**Our Case Number:** ABP-314724-22

**Re:** Railway (Metrolink - Estuary to Charlemont via Dublin Airport) Order [2022]  
Metrolink. Estuary through Swords, Dublin Airport, Ballymun, Glasnevin and City Centre to  
Charlemont, Co. Dublin

**314724: Metrolink Railway Order Submission  
16<sup>th</sup> January 2023**

COLLINS AVENUE STATION

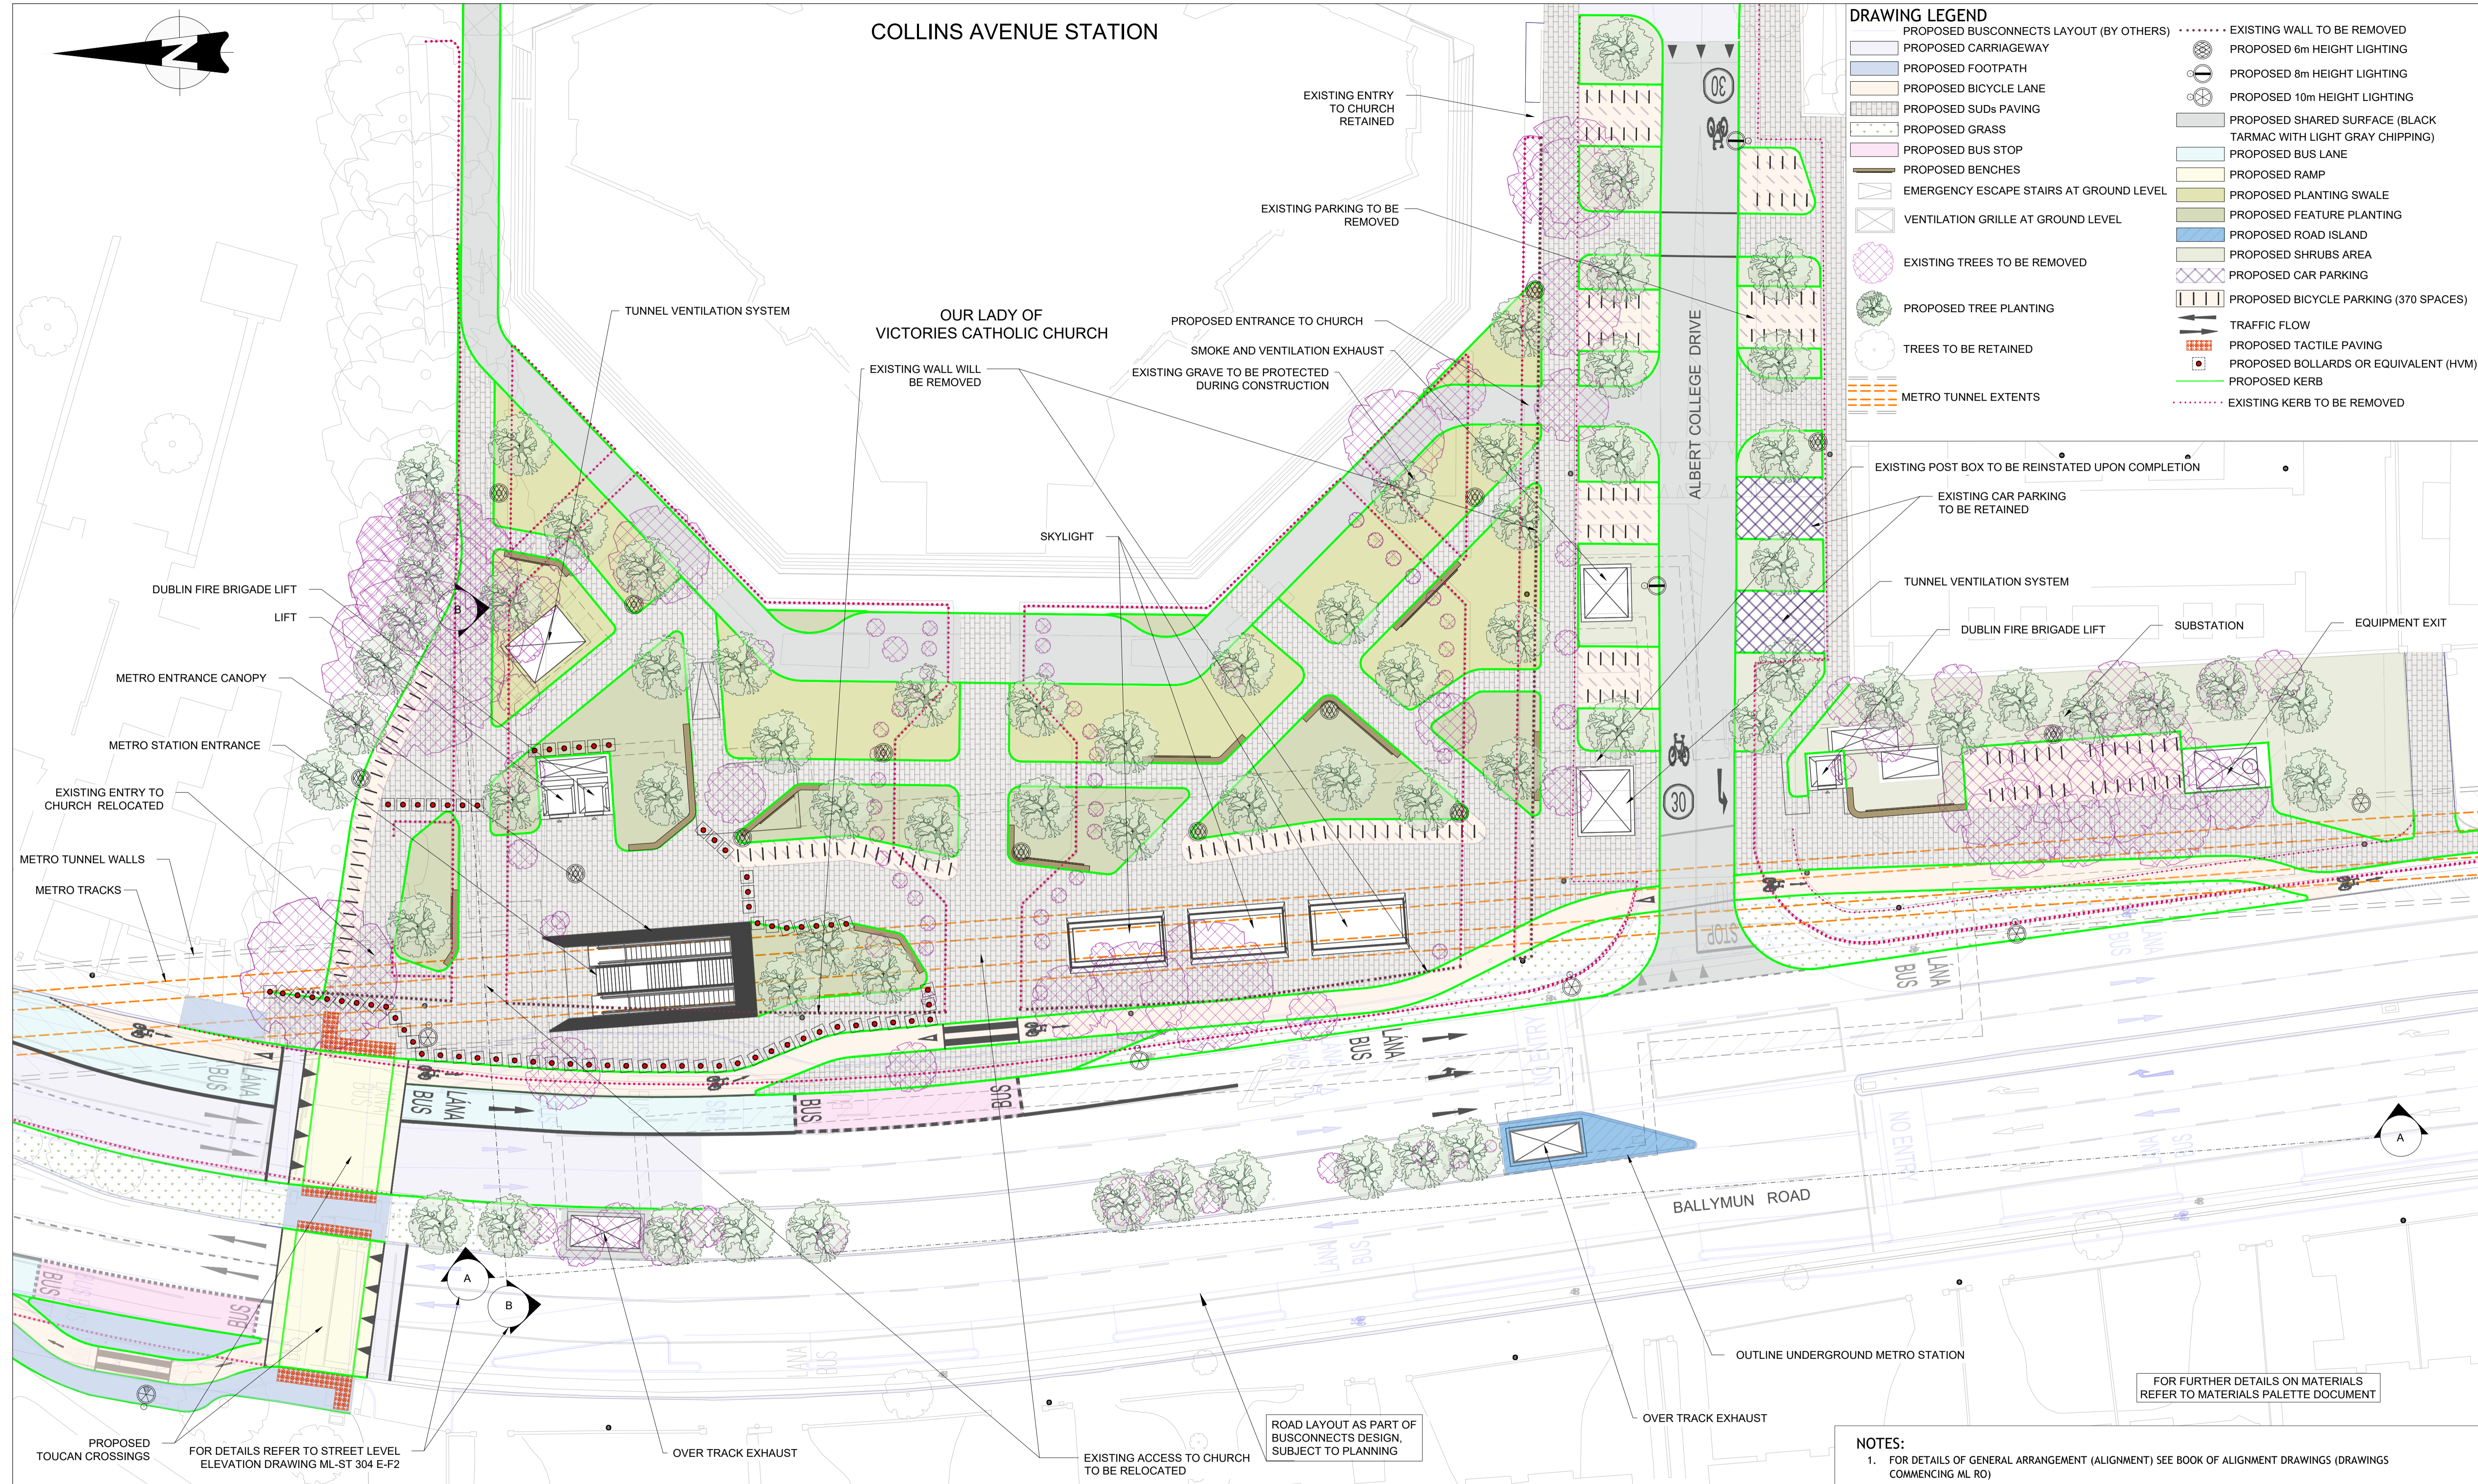
The proposed location of the Collins' Ave station and the associated Intervention Shaft in Albert College Park has caused concern among some residents in the Dublin North-West Constituency.

There is local concern that placement of the Metro Station on Collins Avenue, beside Our Ladies of Victory Church, is likely to pose a number of challenges. There are two primary schools located opposite the proposed location of the Collins Avenue Station: Our Lady of Victories Girls School and Our Lady of Victories Boys School. It is feared that the location of the station could pose safety concerns for children accessing the schools as well as

difficulty for parents dropping their children off at school as parking spaces will be reduced due to construction works. There is a high proportion of older residents in the constituency, most notably in the two senior citizen complexes in the Albert College estate. This accommodation is located right beside the proposed Collins Avenue Metro Station and these residents are concerned about noise and vibrations from the construction work and loss of parking spaces. The issues affecting these residents must be addressed and their concerns addressed.

There have been suggestions from residents to move the Collins Avenue Station to Albert College Park, as originally planned in the Metro North project. Given the requirement for an intervention shaft in Albert College Park, it is argued that it would be less disruptive overall to locate a station there rather than at the proposed Collins' Avenue location. TII should provide their reasoning for locating the station at Collins Avenue and if this is to go ahead, they must work closely with residents to address their concerns and minimise the negative impacts.

ALBERT COLLEGE PARK INTERVENTION SHAFT. PLAN
SCALE 1:400

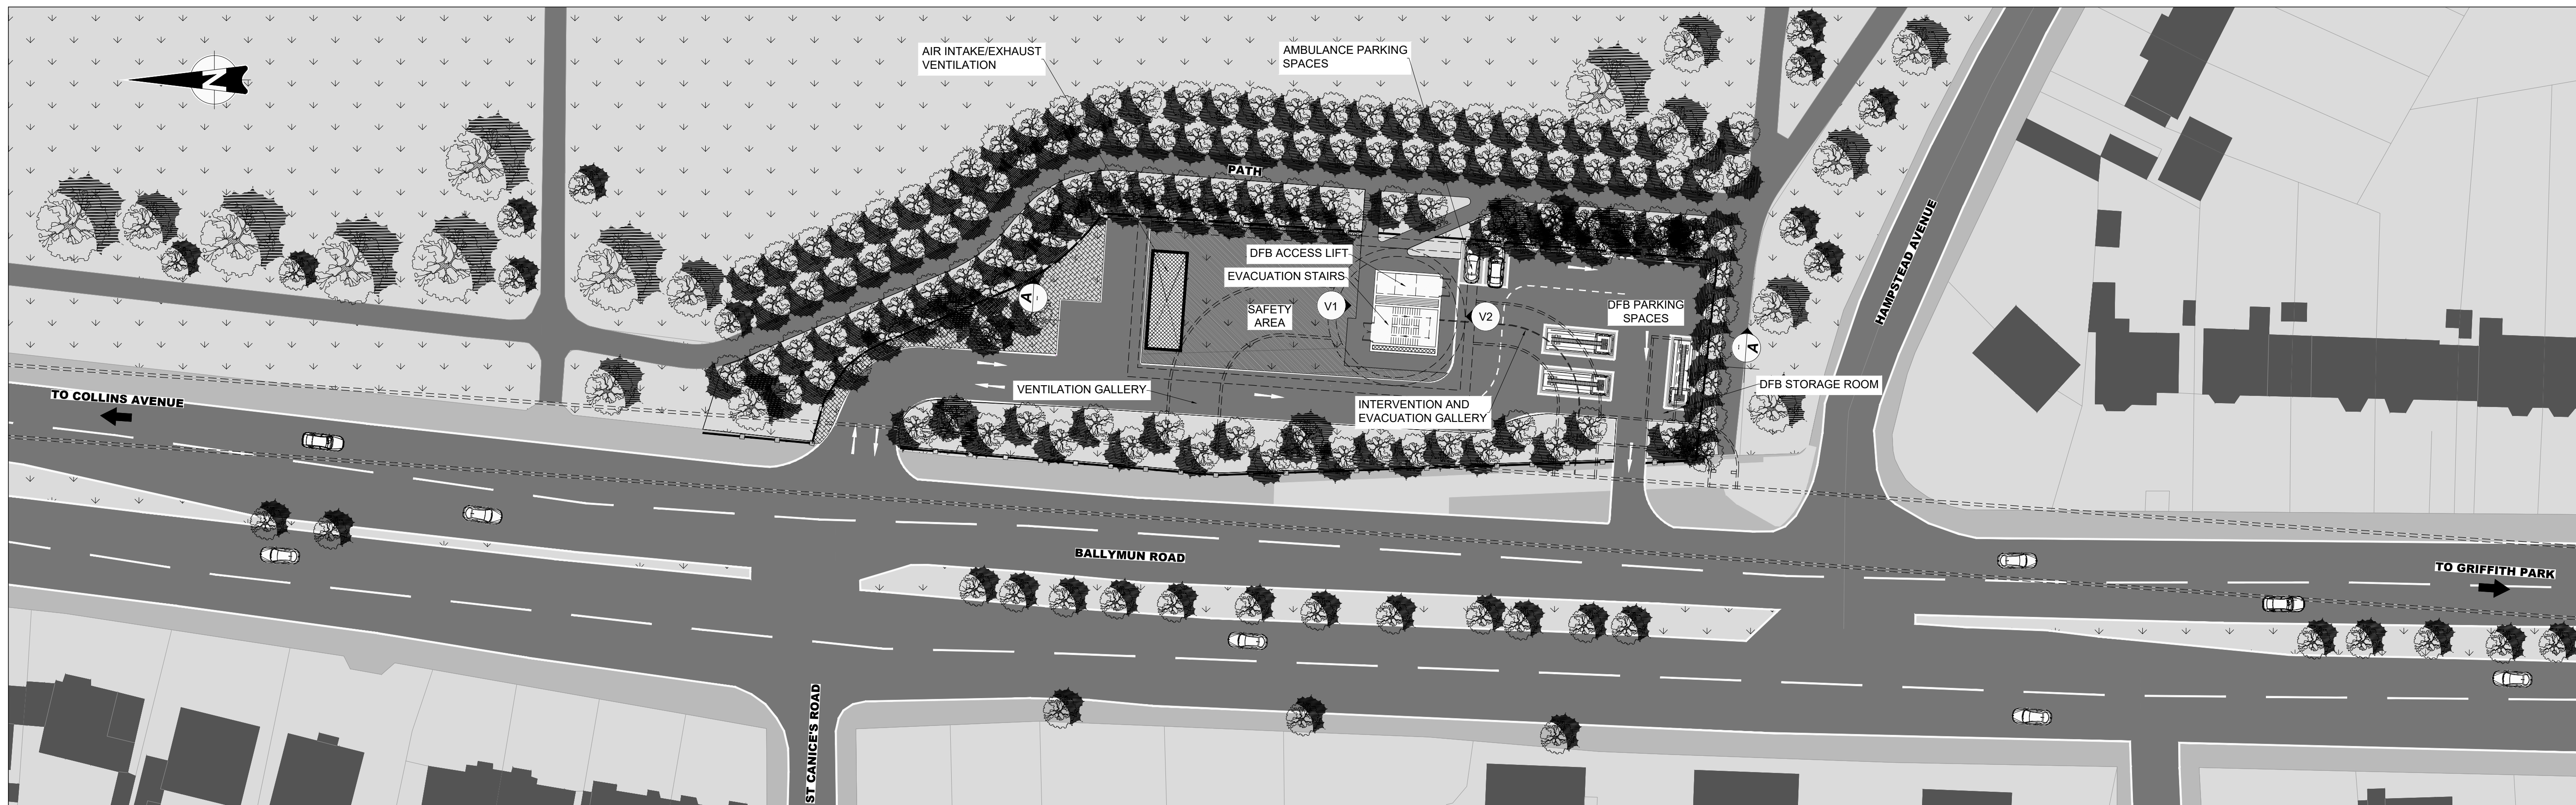
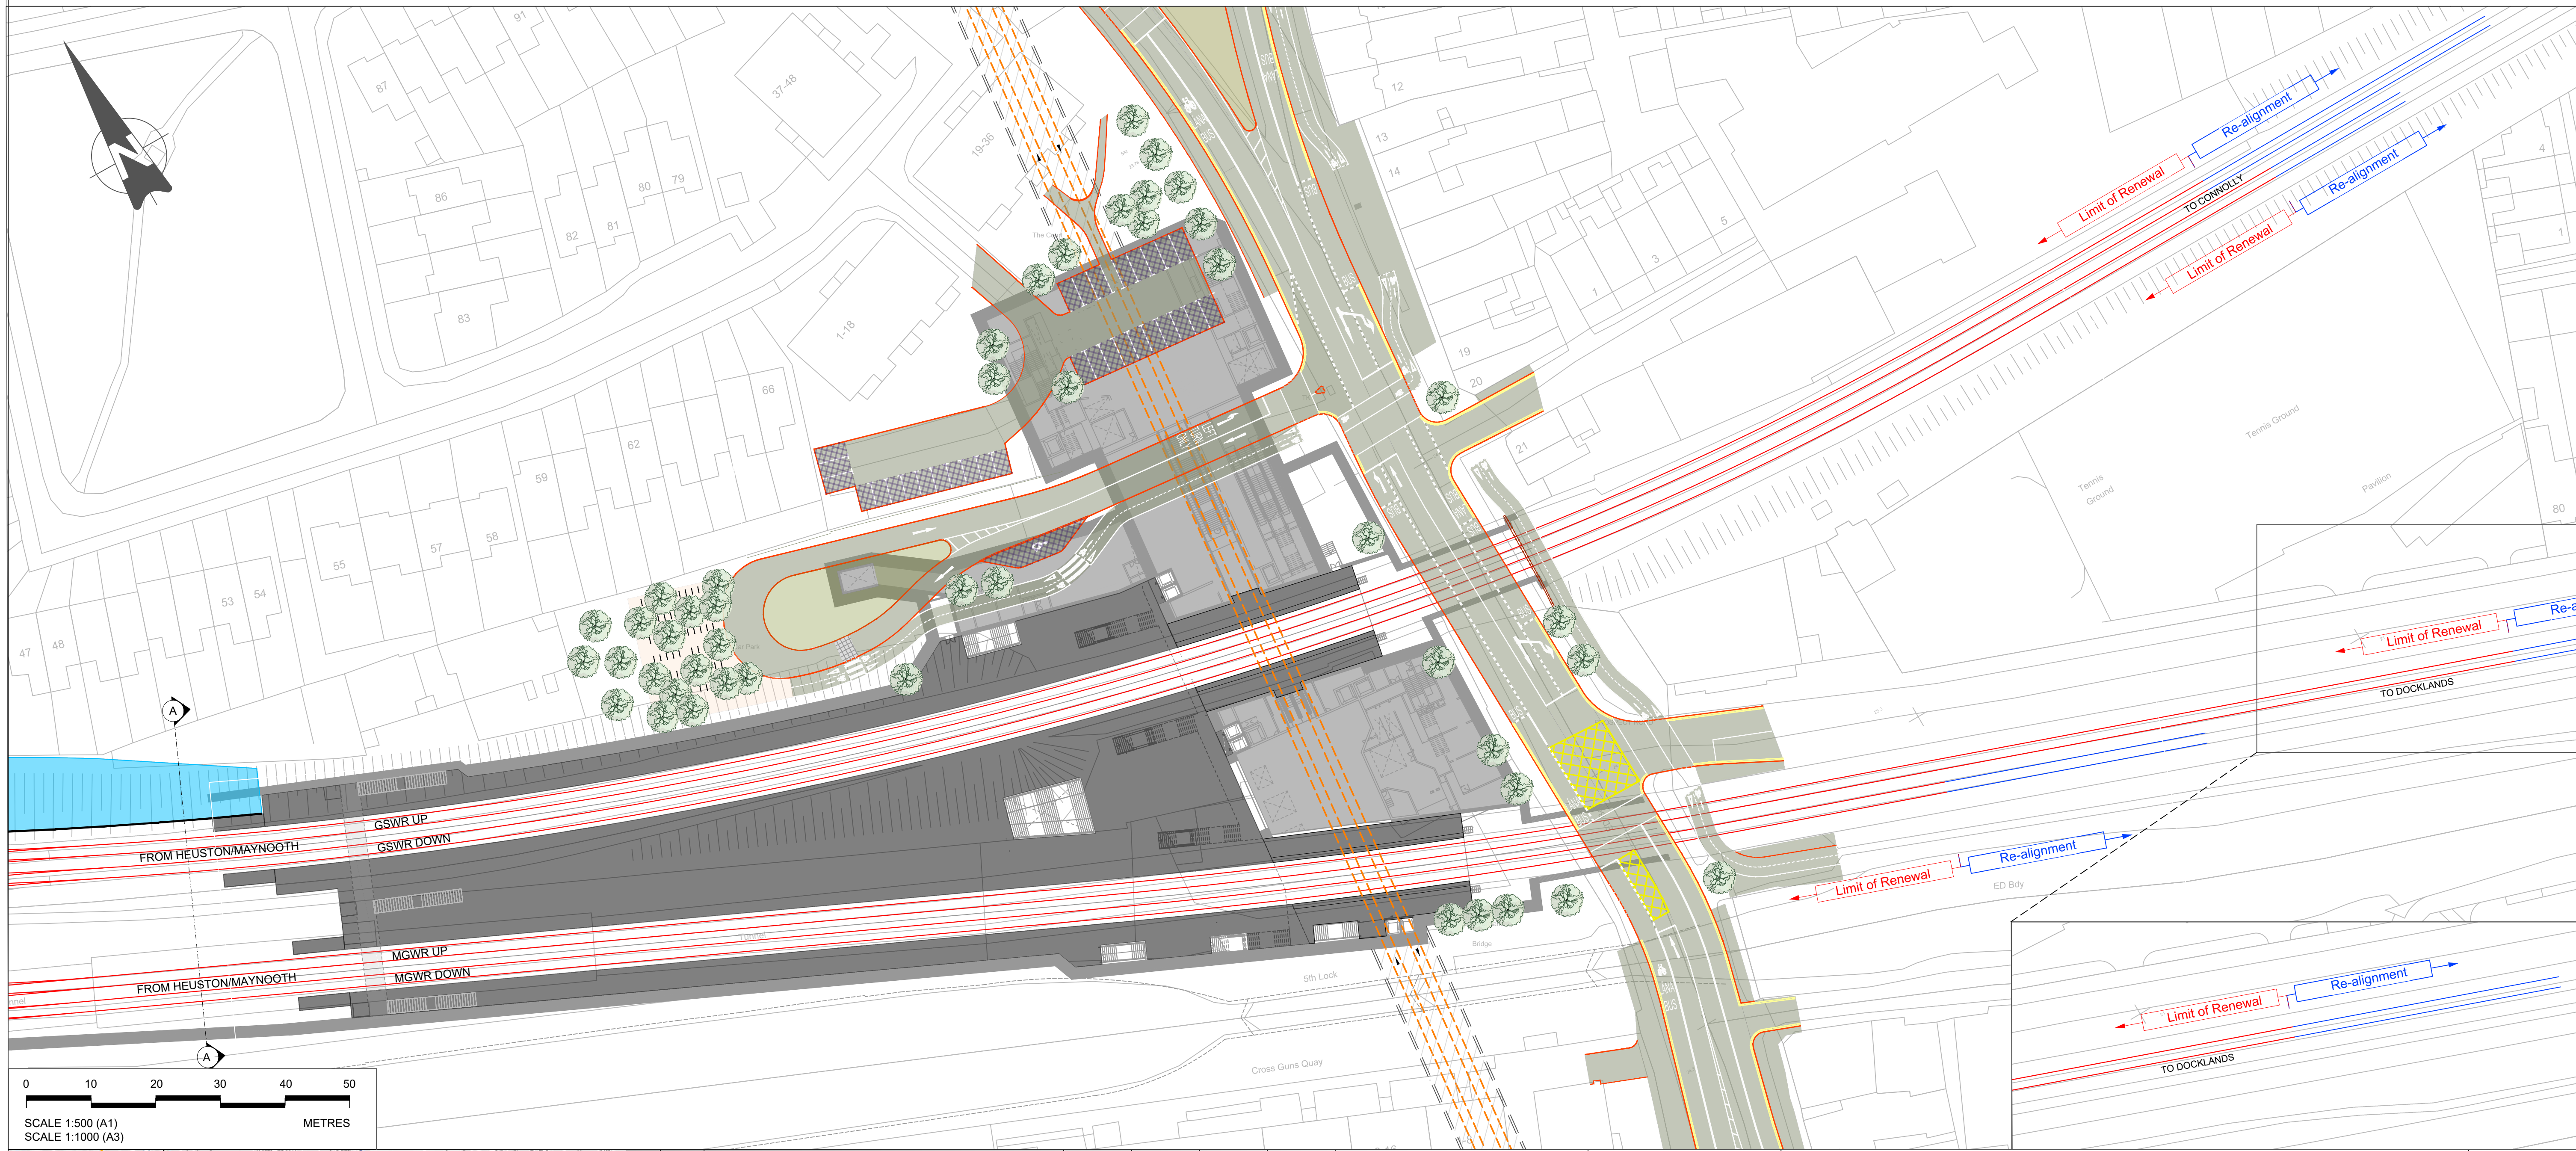
There should be a similar responsibility on TII to monitor and detail how run-off water, or disturbed underground water will be managed in Albert College Park, and also to detail how toxic fumes will be managed. This of key importance for those living on Hampstead Avenue as it is within 20 metres of the proposed Intervention Shaft

In the event that the Collins' Avenue station remains as part of the scheme, we are told that the Intervention Shaft is a necessary part of the project. Its function is to allow emergency services to access the underground system in an emergency situation and to provide a safe route for passengers to escape from the tunnel in the event of an emergency. However, regarding the current plans for the intervention shaft in Albert College Park, it appears that the scale of the structure need not be as large as required. The shaft footprint includes an emergency service parking area, but this could be accommodated outside of the park on the Ballymun Road.

Furthermore, the sections of the park that are being temporarily acquired under the Railway Order for the relining of the football pitches should only be for the duration of the relining works and not for period of the construction of the Intervention Shaft nor for the placement of spoil. It is imperative that both the community and local sports groups not lose access to these sports pitches for any longer than absolutely necessary.
